Subject: Roberts Oil Company Drainage Plan,  
1600 Eubank Blvd. NE

RE: ROBERTS OIL COMPANY DRAINAGE PLAN, 1600 EUBANK N.E.

Re: Roberts Oil Co. Drainage Plan

JOB NUMBER 29	DATE 12-1-80	FOUNDATION PERMIT
PROJECT ROBERTS OIL - OFFICE BLDG LIQUOR STORE & GAS STATION	DRAWN R.C.	CHECKED T.M.
OWNER BILL ROBERTS	TITLE GRADING PLAN	
GATHMAN-MATOTAN ARCHITECTS-PLANNERS INC.		
TELEPHONE (505) 265-8338 230 TRUMAN N.E. ALBUQUERQUE, NEW MEXICO 87108		
SHEET 3 OF 3

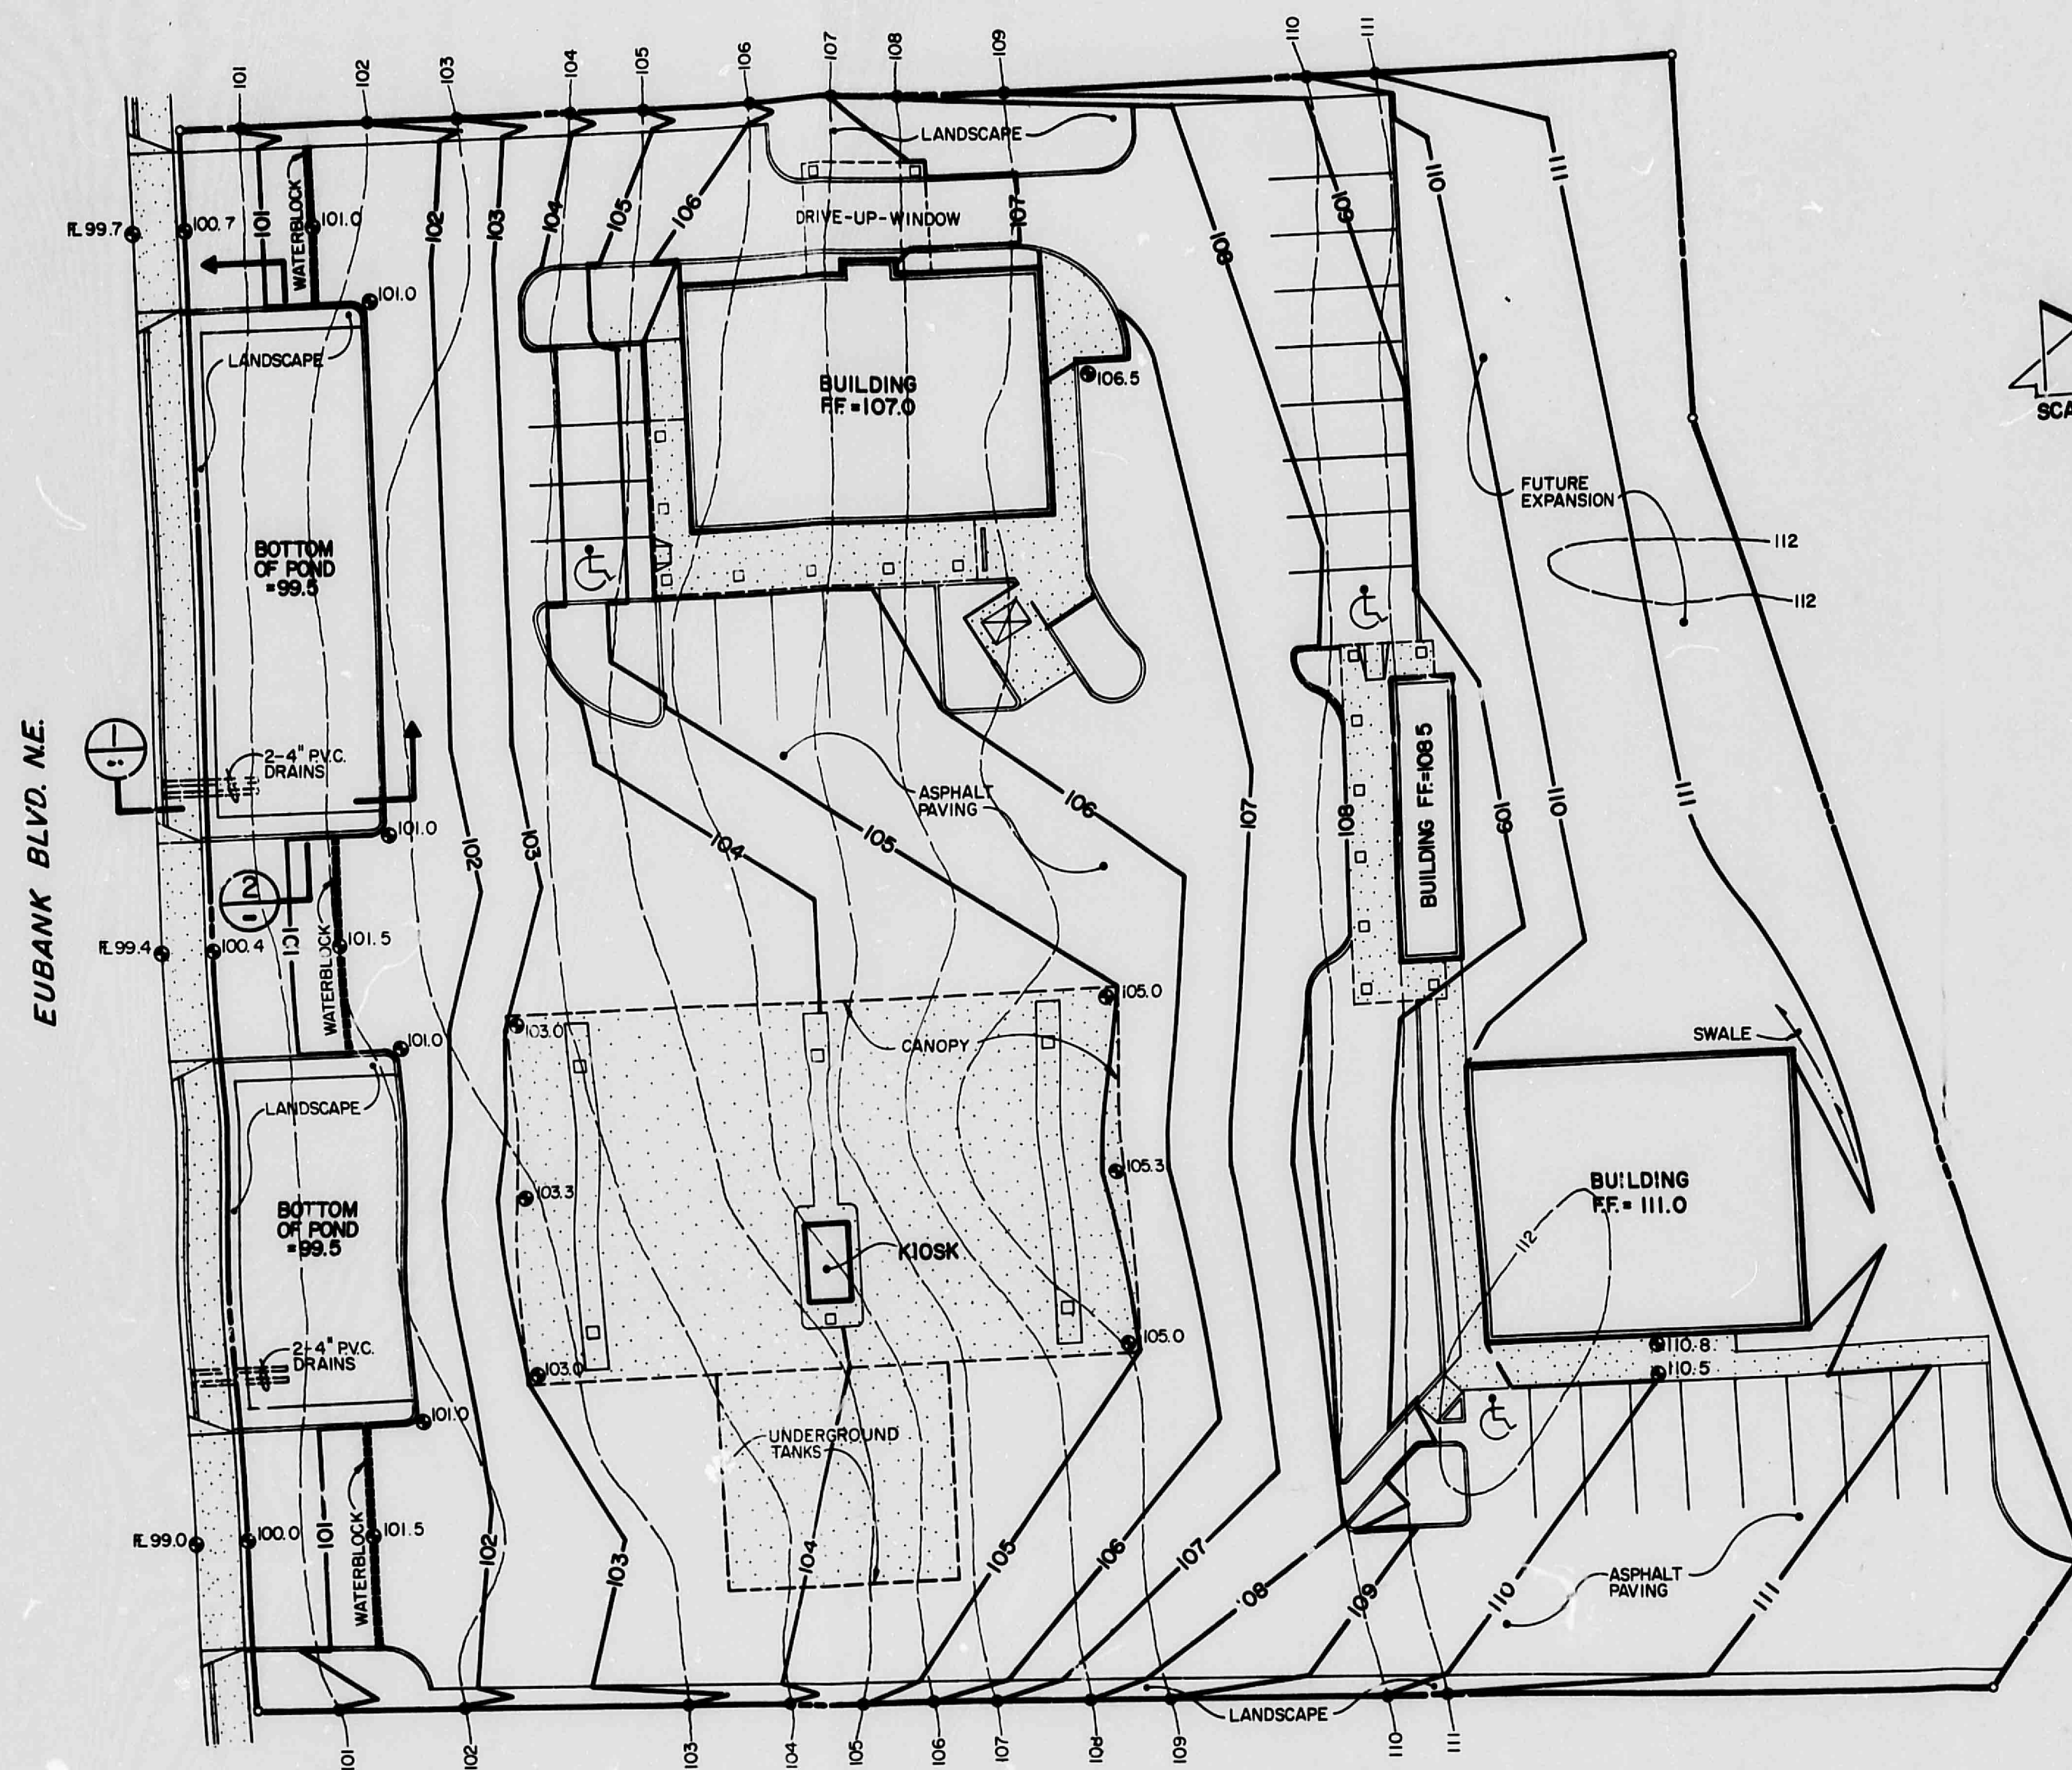
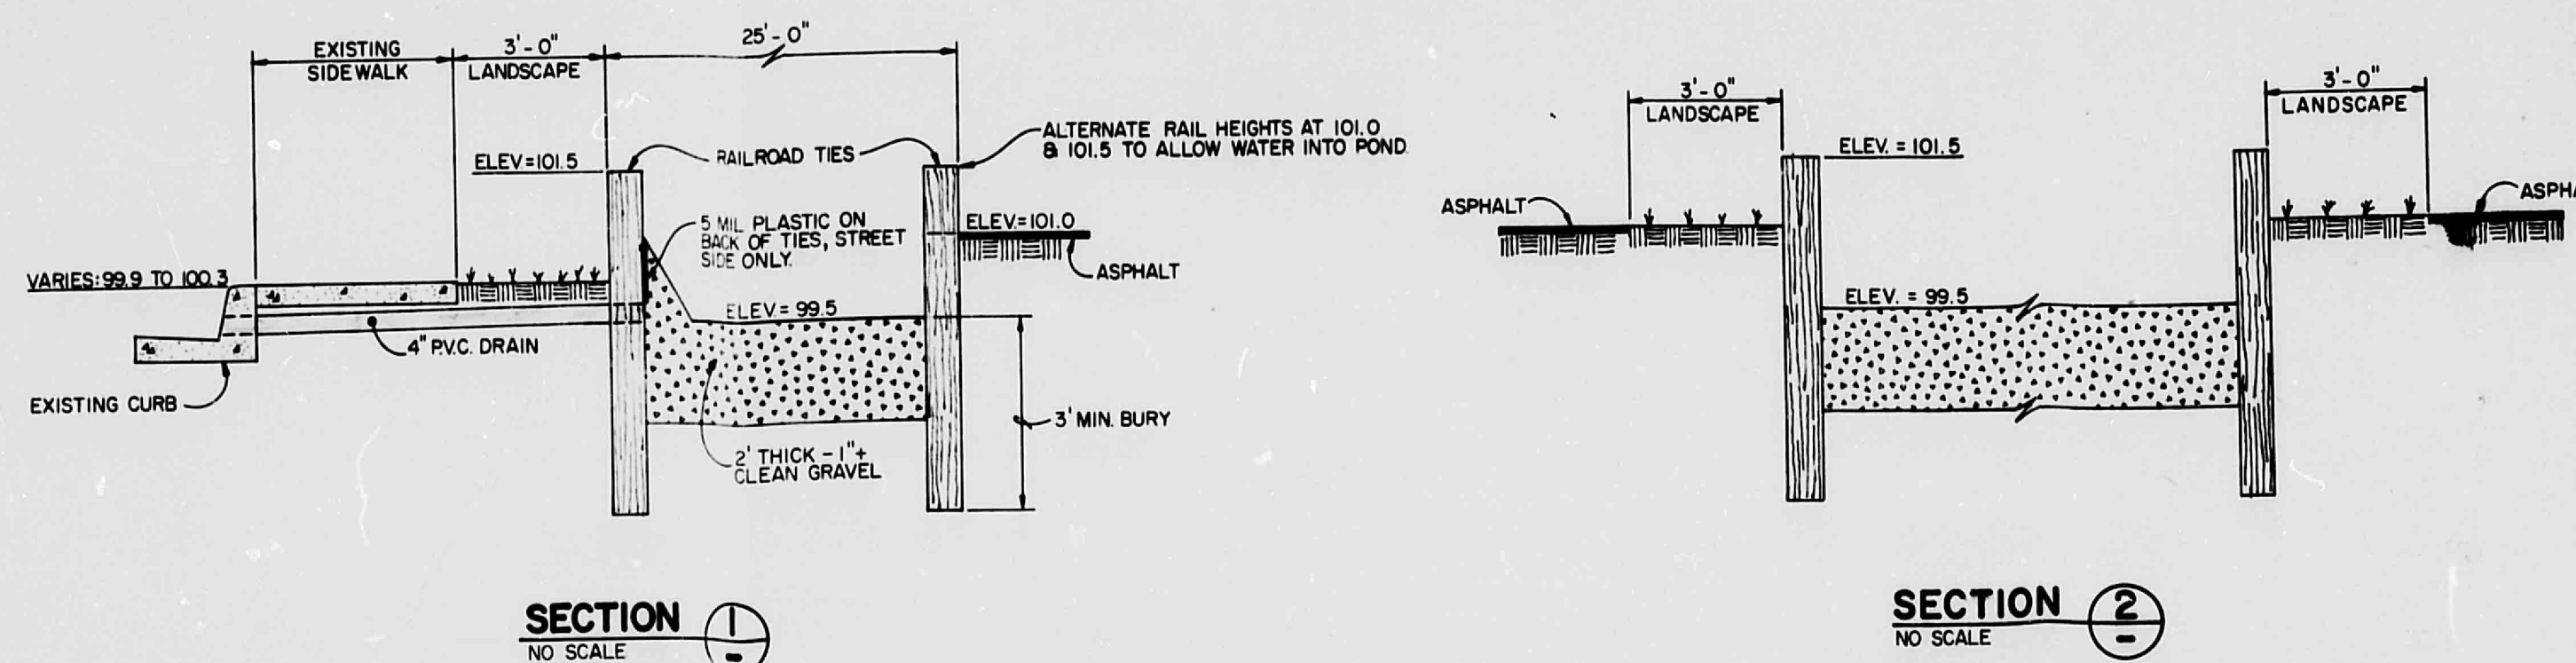
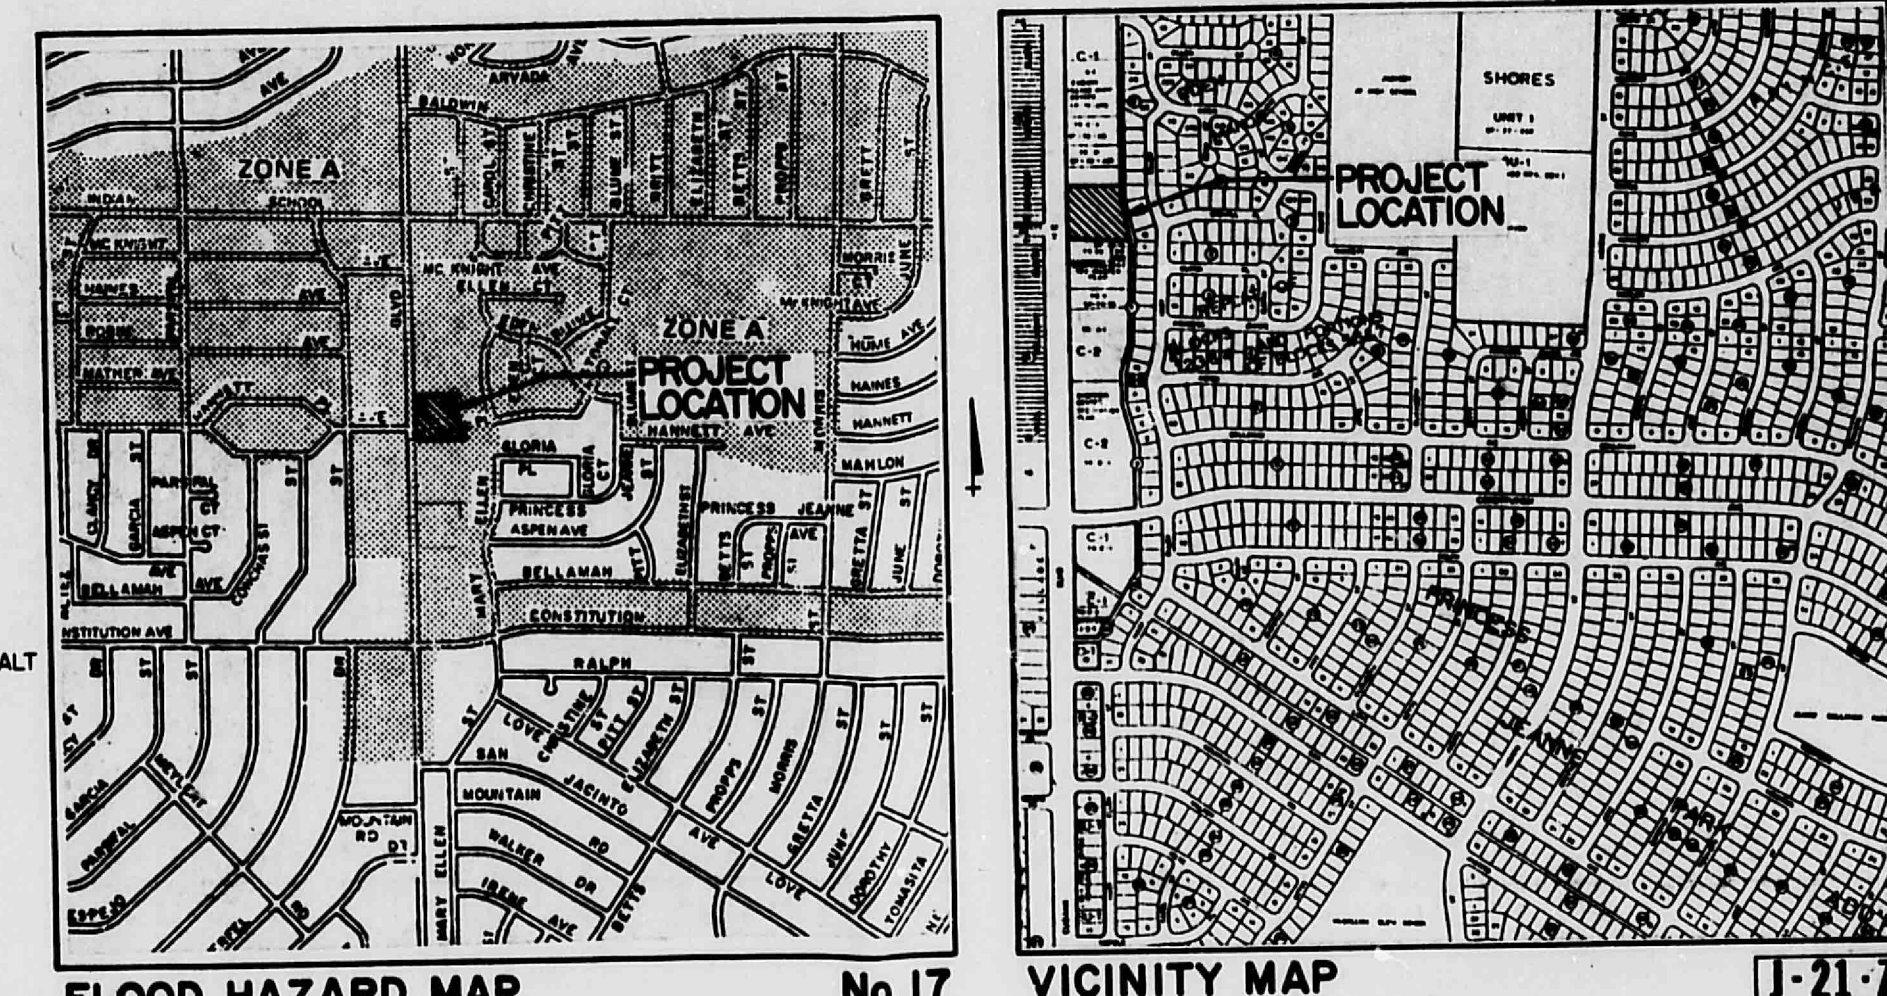
1. Submittal of a revised grading plan replacing sheets 3 and 3A of your construction plans, with alley grades established by the City Engineers Office, Design Section, and signed by your engineer, Mr. Tom Mann.
2. Compliance with the City's comments when the revised plan (Point 1) is reviewed.
3. Acceptance of any responsibility for conflicts between the proposed alley grades and the grades shown on the grading plan.
